Rezoning Transportation Analysis

Petition Number: 2020-099

| Date | Description |
|----------|-------------------|
| 10-28-20 | Third Review (KP) |
| 11-12-20 | Fourth Review |

JOB NO: 651032401
 DATE: 11/05/20
 SHEET: **RZ-1**

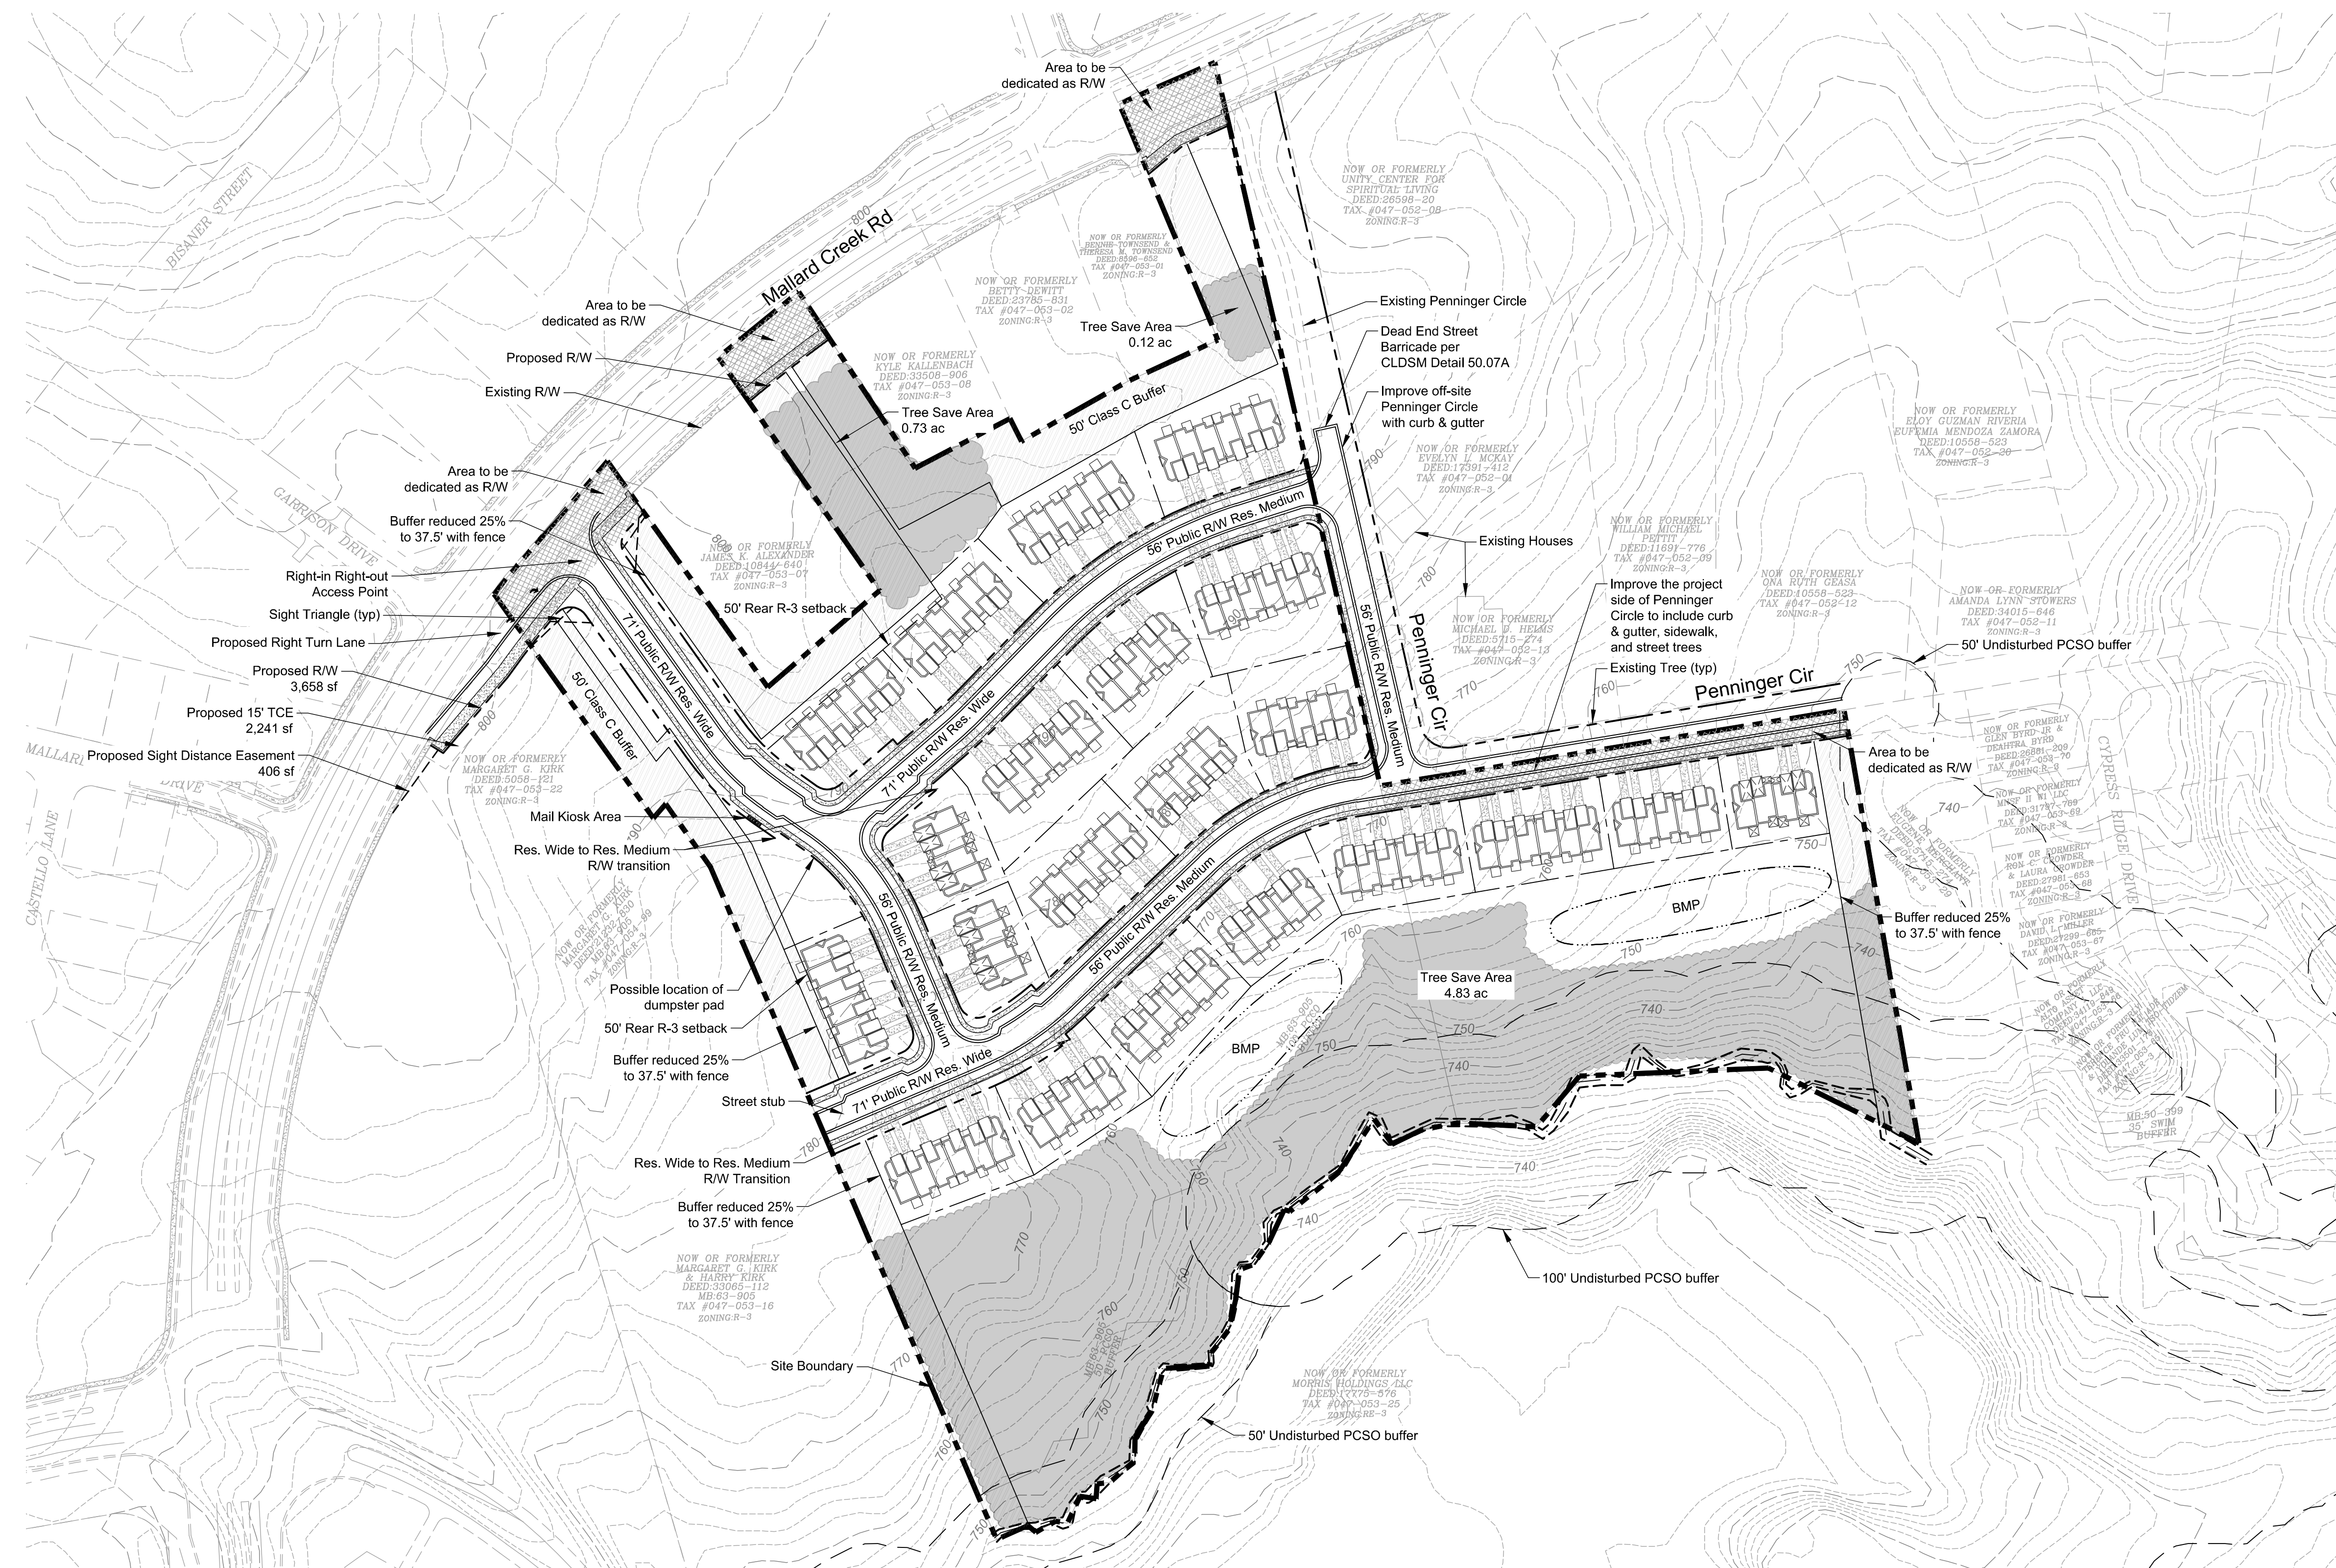
6. ~~**Outstanding** The petitioner should revise the site plan and conditional note(s) to restrict the proposed access on Mallard Creek Road to a right-in/right-out, with right-turn lane (100-ft storage with appropriate bay taper) on Mallard Creek Road at the proposed access location.~~

- a. ~~**Technical Clarification (site plan dated 09/14/20)** The petitioner should clarify conditional note (Section 3.D.) that a proposed right-turn lane will be constructed at the proposed Mallard Creek Road right-in/right-out access. The proposed right-turn lane should have 100 linear feet of storage with the appropriate bay taper length, according to NCDOT design standards.~~

9. ~~The petitioner should remove the proposed access on Mallard Creek Road, as shown below; NCDOT does not support an access at this location of Mallard Creek Road, in reference to the STIP's u-turn bulb-out. Please revise the site plan to provide adequate access for the existing single-family properties, using the proposed USDG Residential Medium/Wide section as proposed below. Please include sidewalk and planting strip on both sides of Penninger Circle.~~

- a. ~~**Technical Clarification (site plan dated 09/14/20)** The petitioner should clarify the site plan to show and call-out the existing Penninger Circle private drive that ties into existing Mallard Creek Road. CDOT requests the petitioner to clarify that the existing Penninger Circle road improvements will be constructed in accordance with *CLDSMU-02 - Local Residential Medium Section* cross section design standards, on both sides of the existing Penninger Circle road centerline.~~
